From: Amanda Scholes on behalf of Planning.Responses
Sent: 12 November 2020 08:55
To: Planning Scanning
Subject: FW: WSCC Highway Comments - BE/121/2- - Revised Construction Management Plan for Saltbox

Please upload onto Ocella the email below which is an additional consultation response from the **Local Highway Authority** to discharge of condition application **BE/121/20/DOC** relating to Salt Box.

Subject: WSCC Highway Comments - BE/121/2- - Revised Construction Management Plan for Saltbox

Logistics and Traffic Management Plans

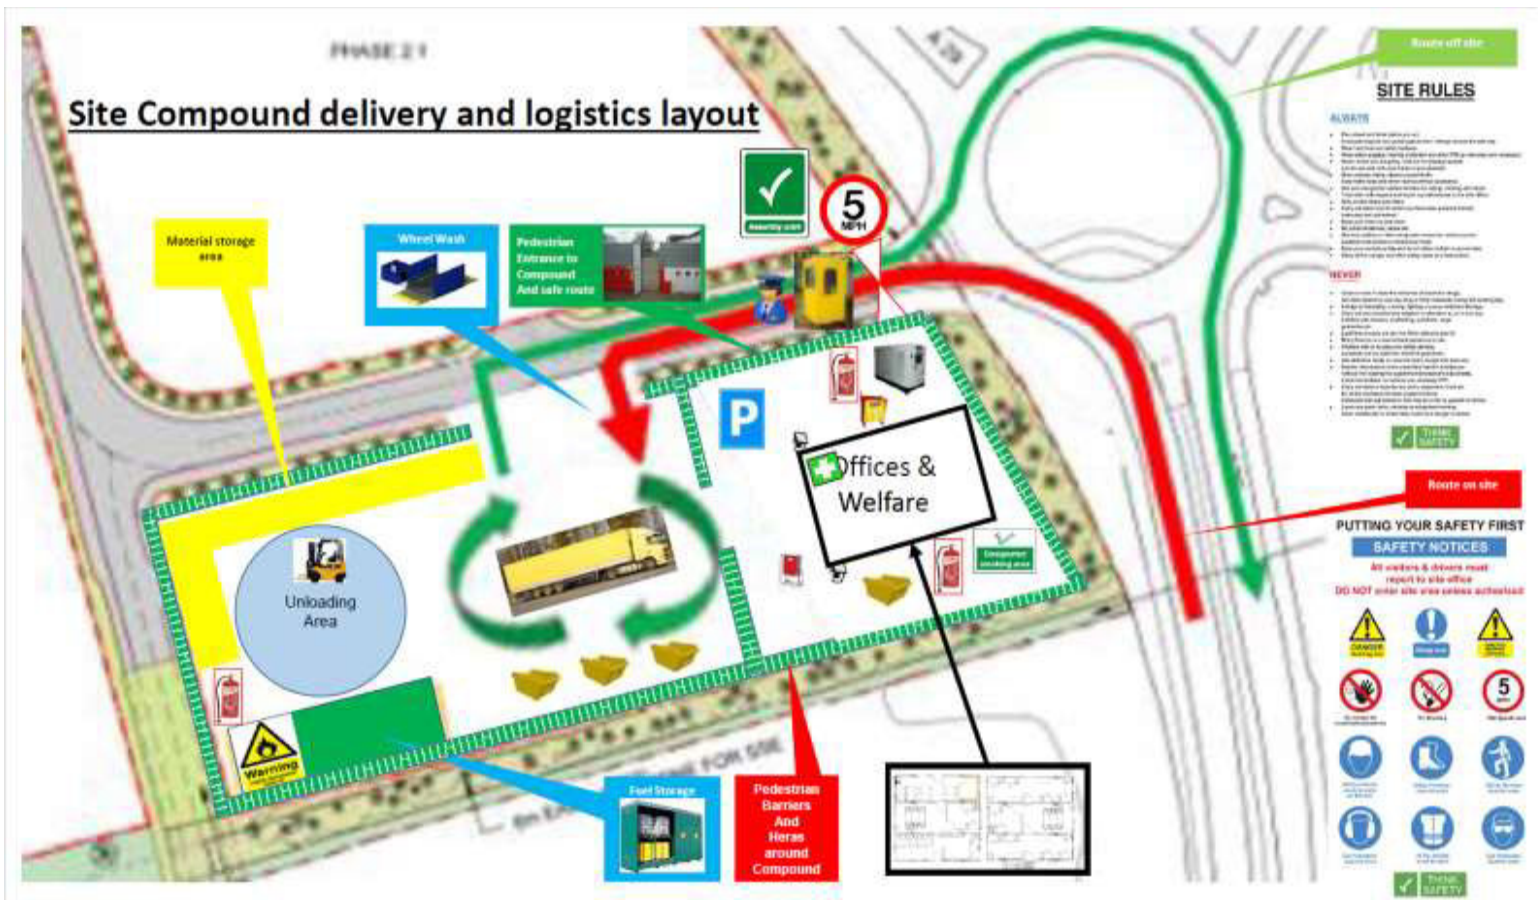
Access is now available from the additional arm off the Felpham Relief Road Roundabout rather than the existing field access to the north, so this has simplified highway matters. The only comment I'd have is in respects of the routing as shown on the Logistics and Traffic Management Plan in appendix 3. This plan shows all deliveries arriving and departing to the south. This isn't an issue in itself, but it is prescribing unnecessarily that all deliveries are required to arrive and depart to the south. There's no reason why traffic couldn't use the A29 to the north or the A259 to the east. I'd have no issue with this plan being amended so as to allow deliveries to arrive via any of the A roads in the vicinity of the site.
